**Re:** Planning Application 18/1085

**Address: 12 Bushburn Drive Langho BB6 8EZ**

**Description: Rear dormer conversion and alterations to front porch.**

PROPOSED PARKING DETAIL SCALE 1:100 @A1

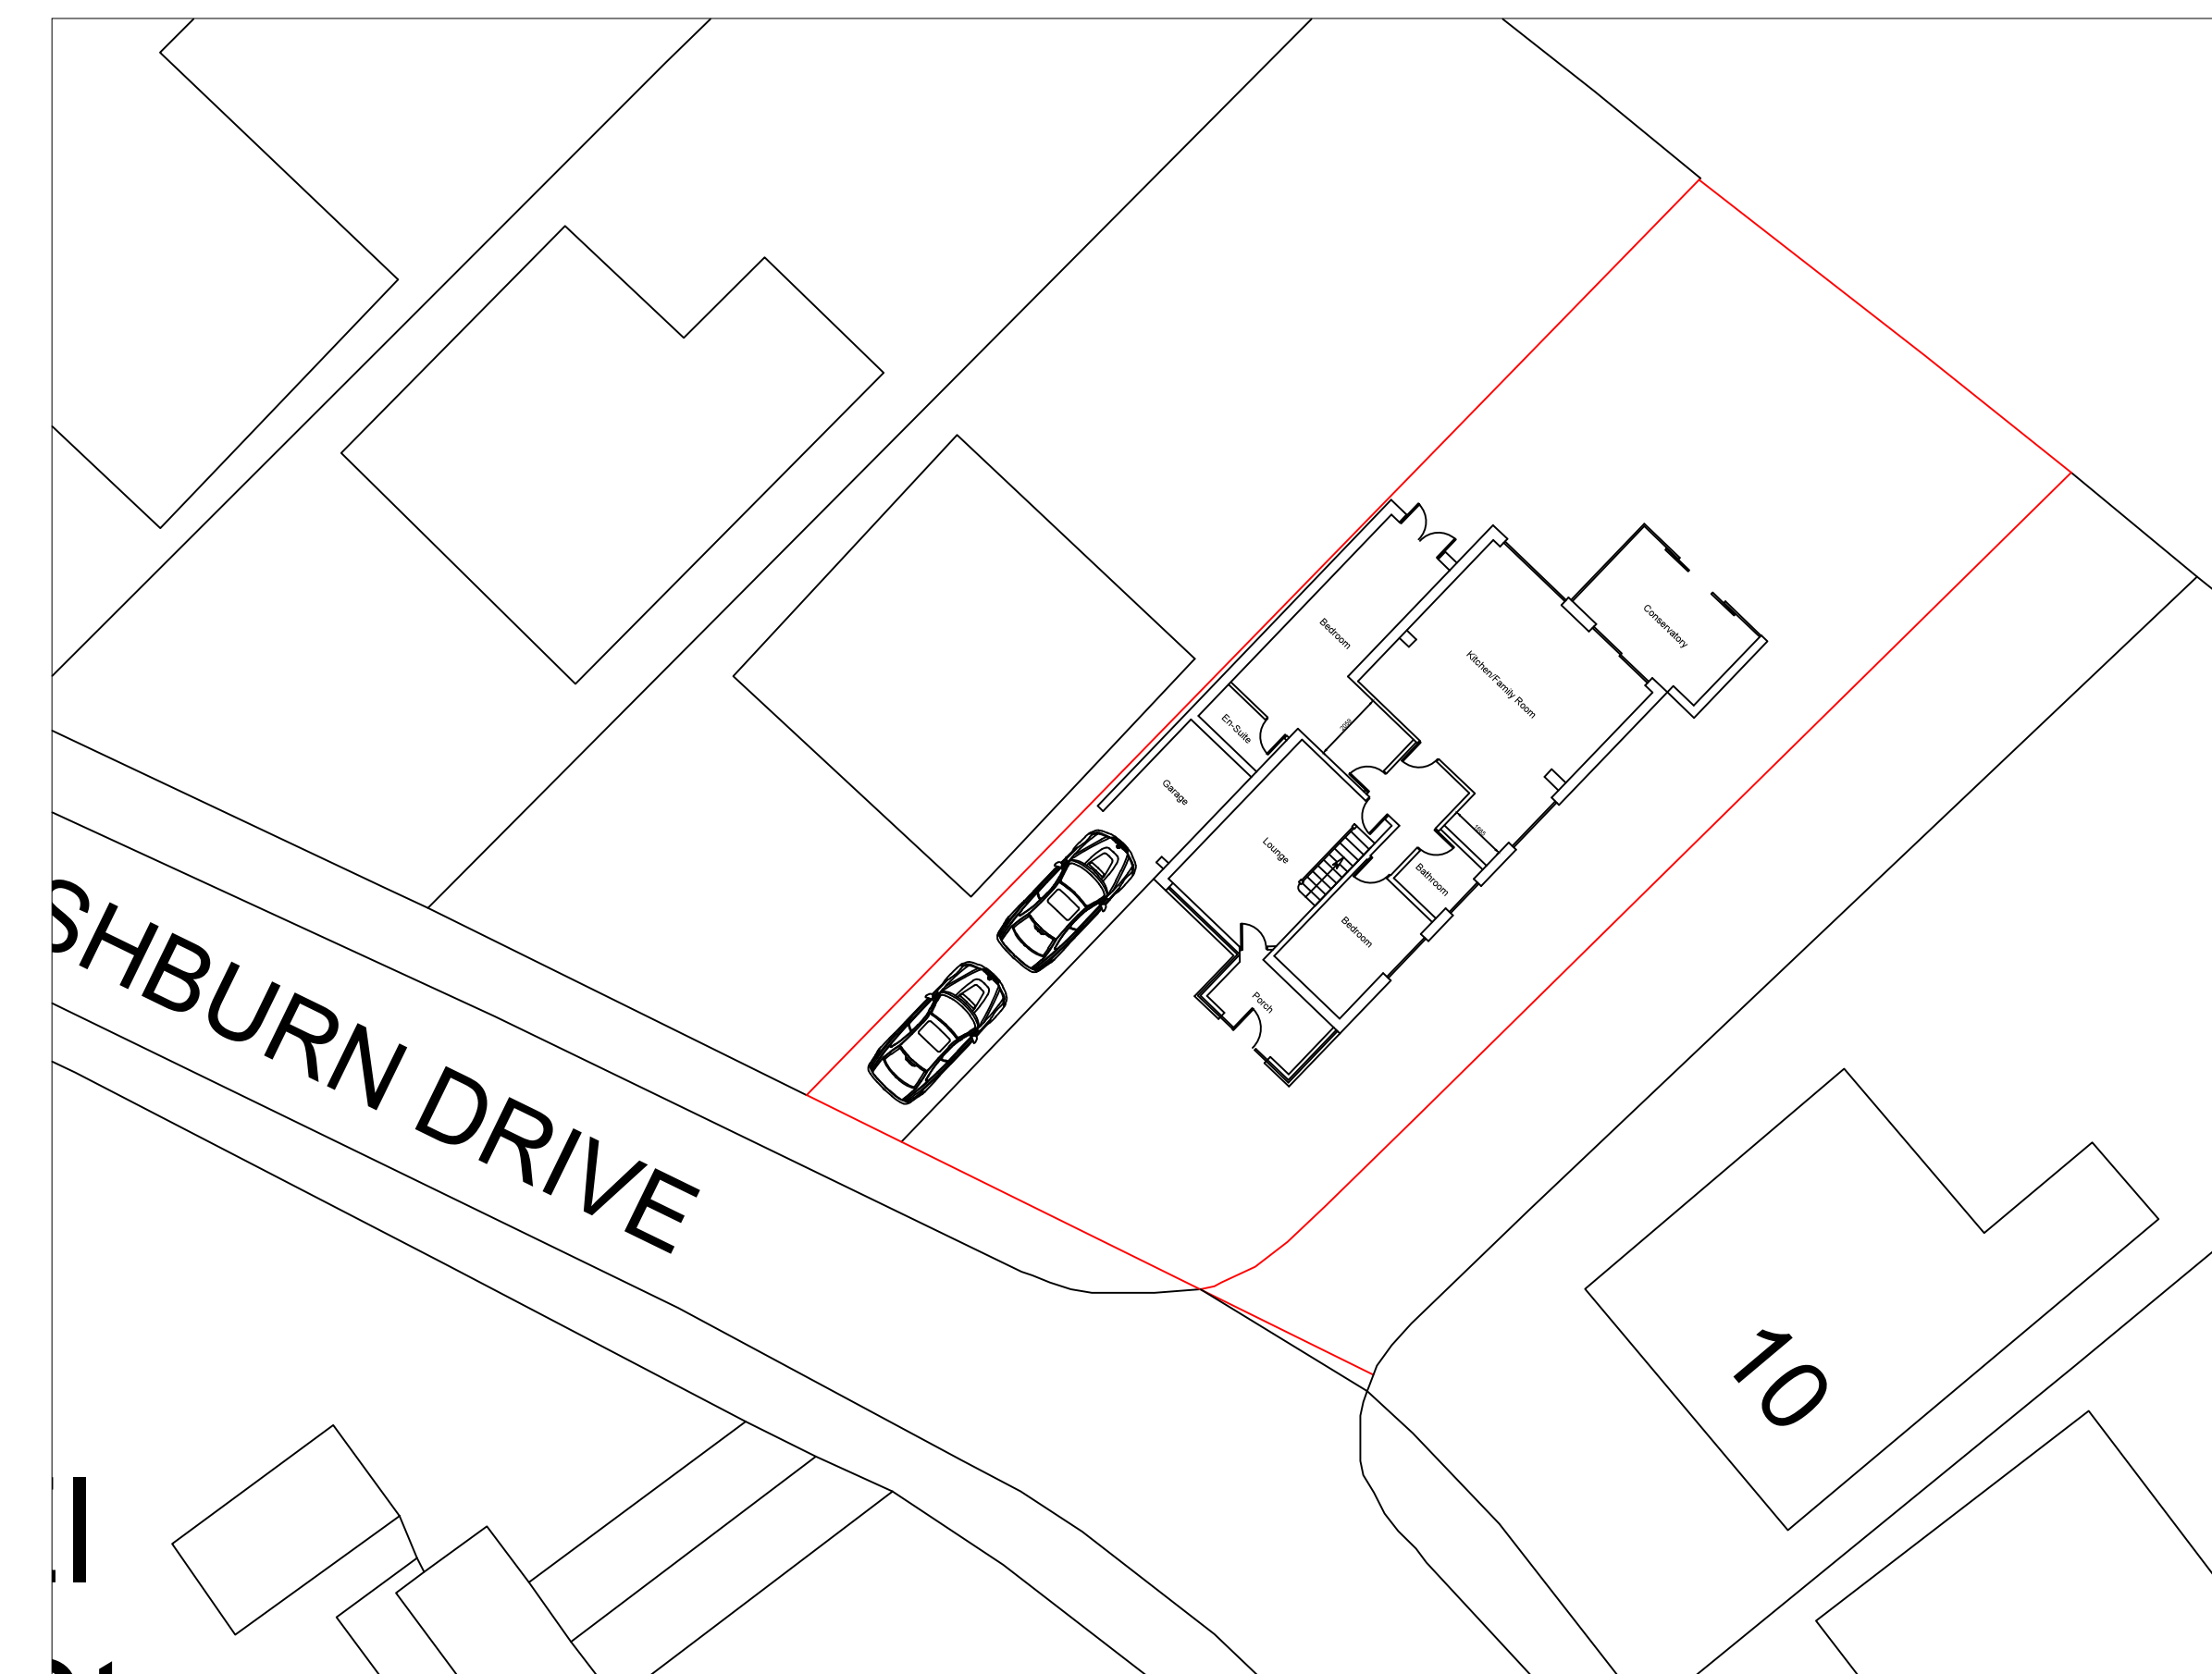
With respect to this application we would no longer wish to raise an objection following the receipt of a further plan showing how the required additional off street parking can be provided.

It is expected that there will be a requirement for an extension to the dropped crossing.

1. The grant of planning permission will require the applicant to enter into an appropriate Legal Agreement, with the County Council as Highway Authority. The Highway Authority hereby reserves the right to provide the highway works within the highway associated with this proposal. Provision of the highway works includes design, procurement of the work by contract and supervision of the works.
